LOT 2, PADMARK BUSINESS PARK FIL. NO. 1

EL PASO COUNTY, STATE OF COLORADO
GRADING & EROSION CONTROL PLAN

GRADING & EROSION CONTROL PLAN
LOT 2, PADMARK BUSINESS PARK FIL. NO. 1
JOB NO. 44-031
DATE PREPARED: FEBRUARY 19, 2018
DATE REVISED: PPR 18-020

EL PASO COUNTY FILE NO. PPR 18-000

GRADING & EROSION CONTROL PLAN
LOT 2, PADMARK BUSINESS PARK FIL. NO. 1
JOB NO. 44-031
DATE PREPARED: FEBRUARY 19, 2018
DATE REVISED:

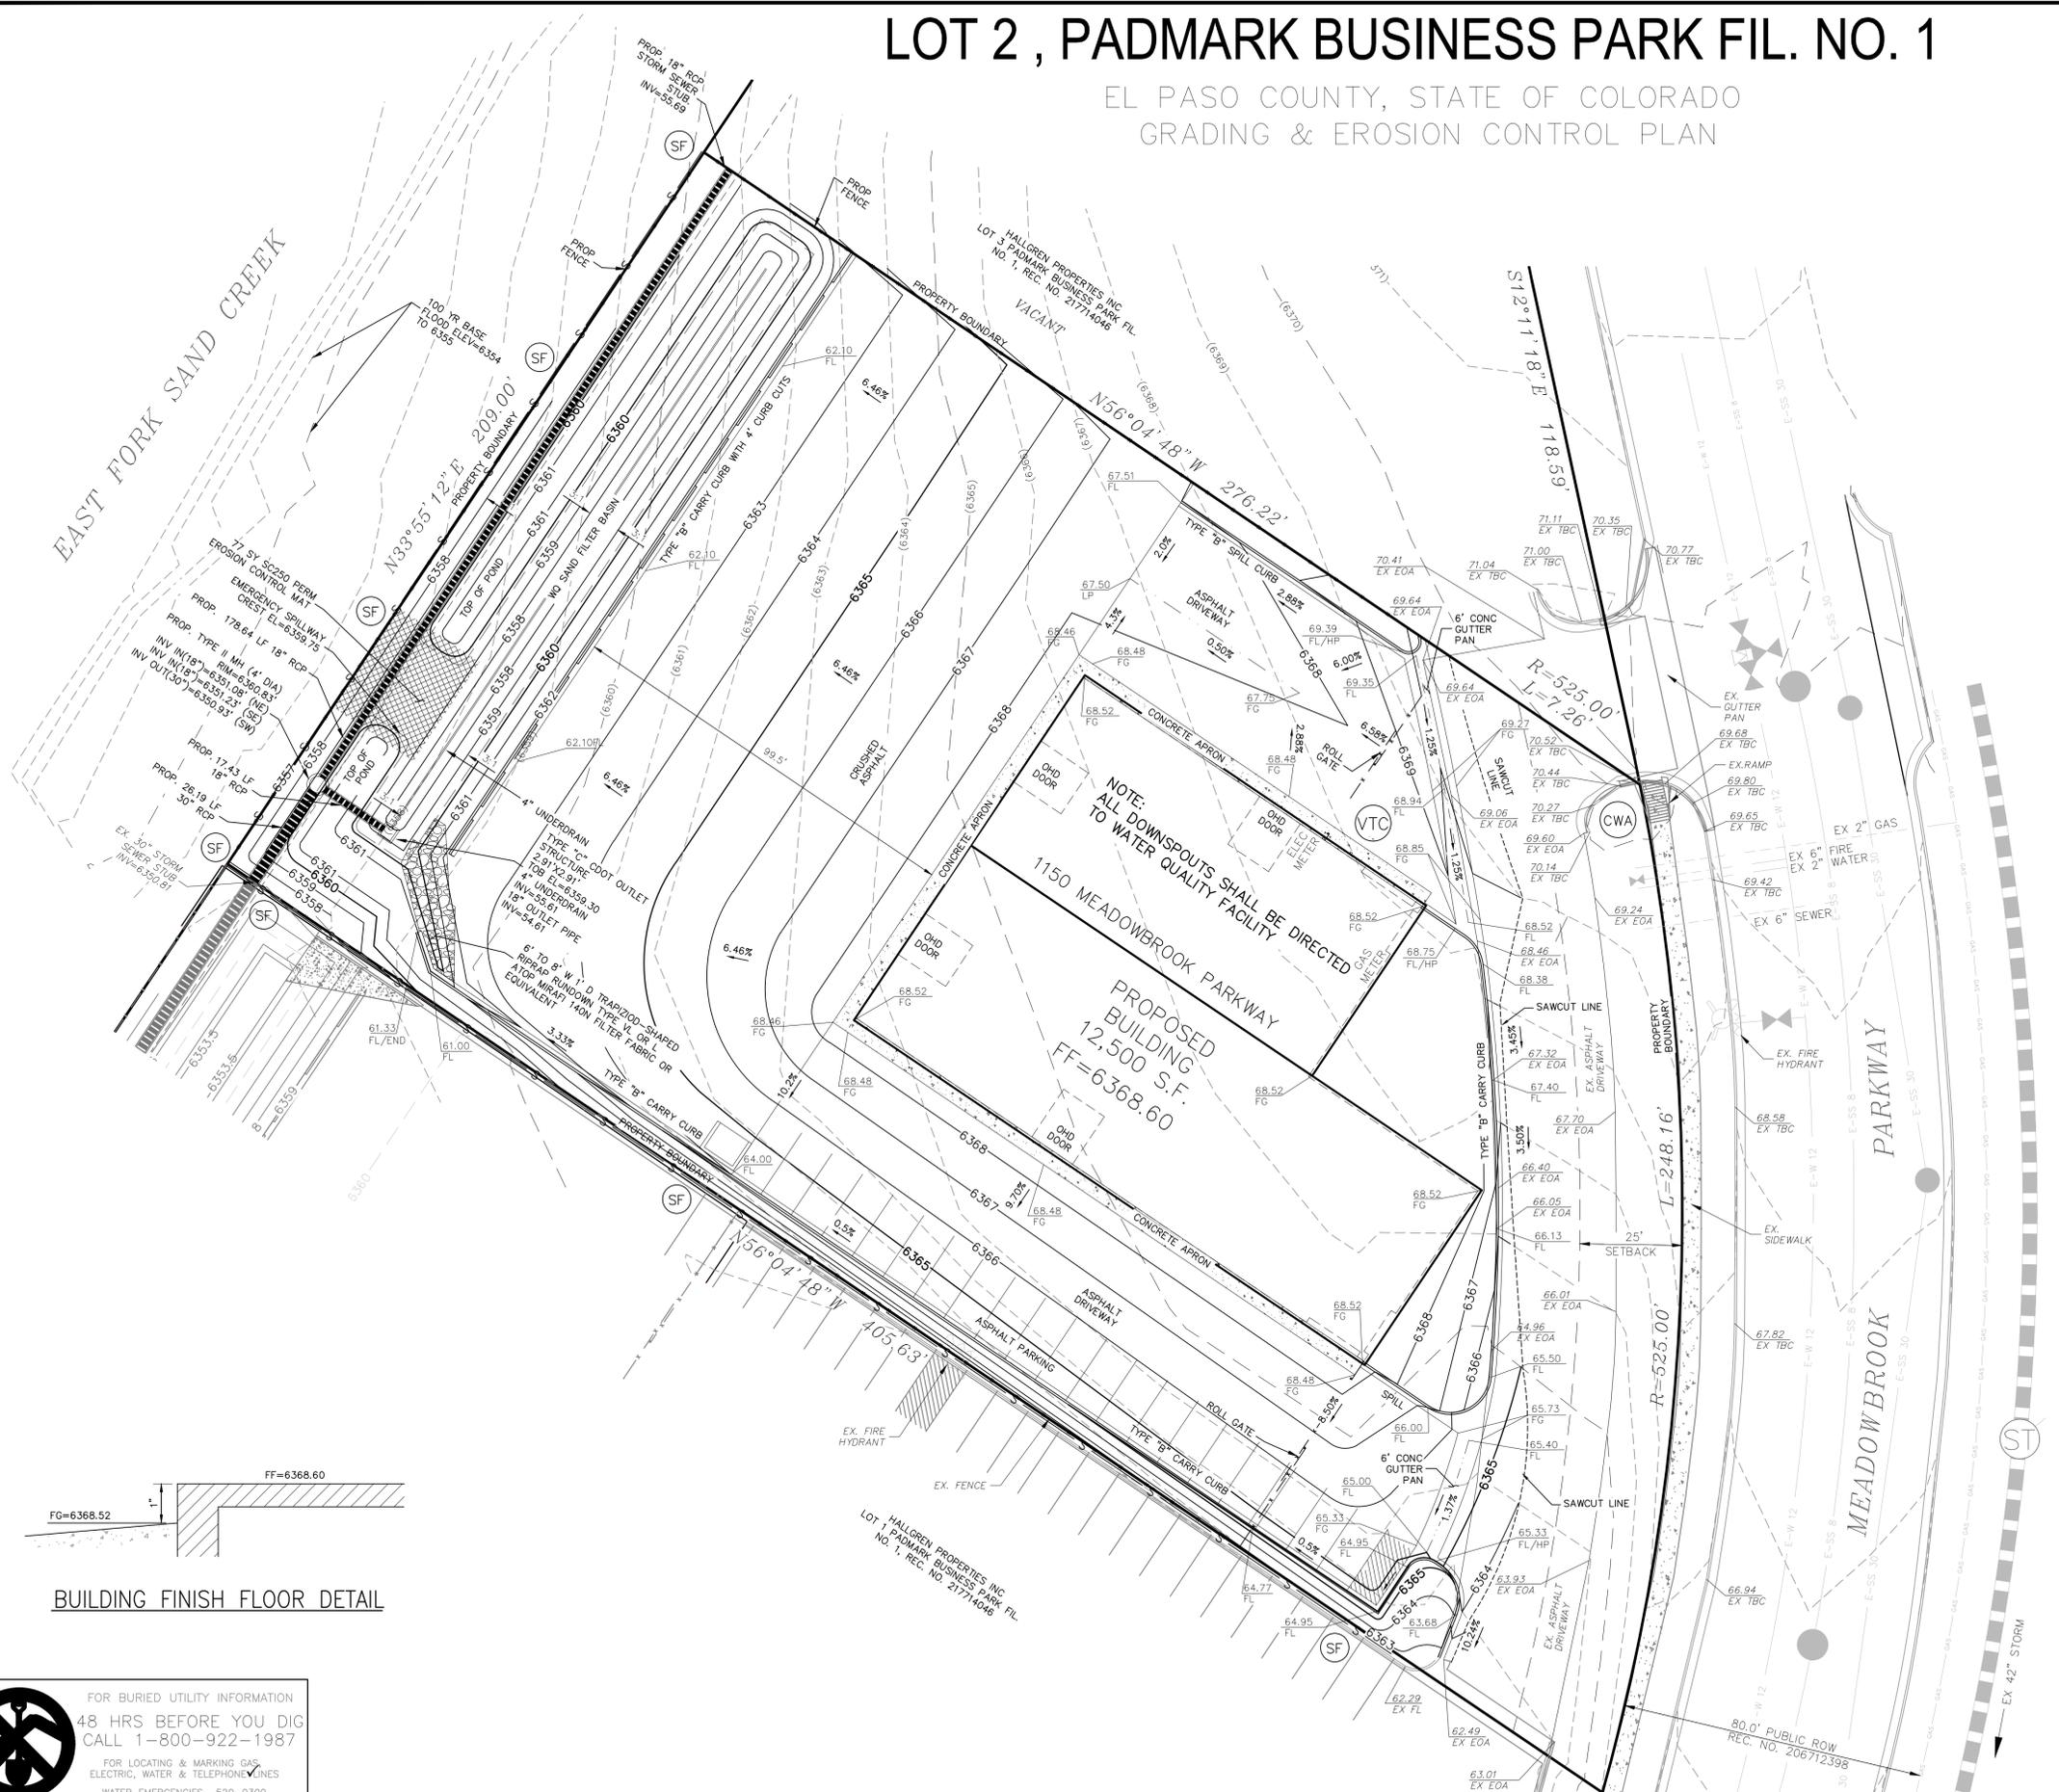
Delineate the limits of disturbance

Provide the easements as shown on the approved plat.

Identify as a temporary sediment basin during construction

Label the slope of the rip rap rundown
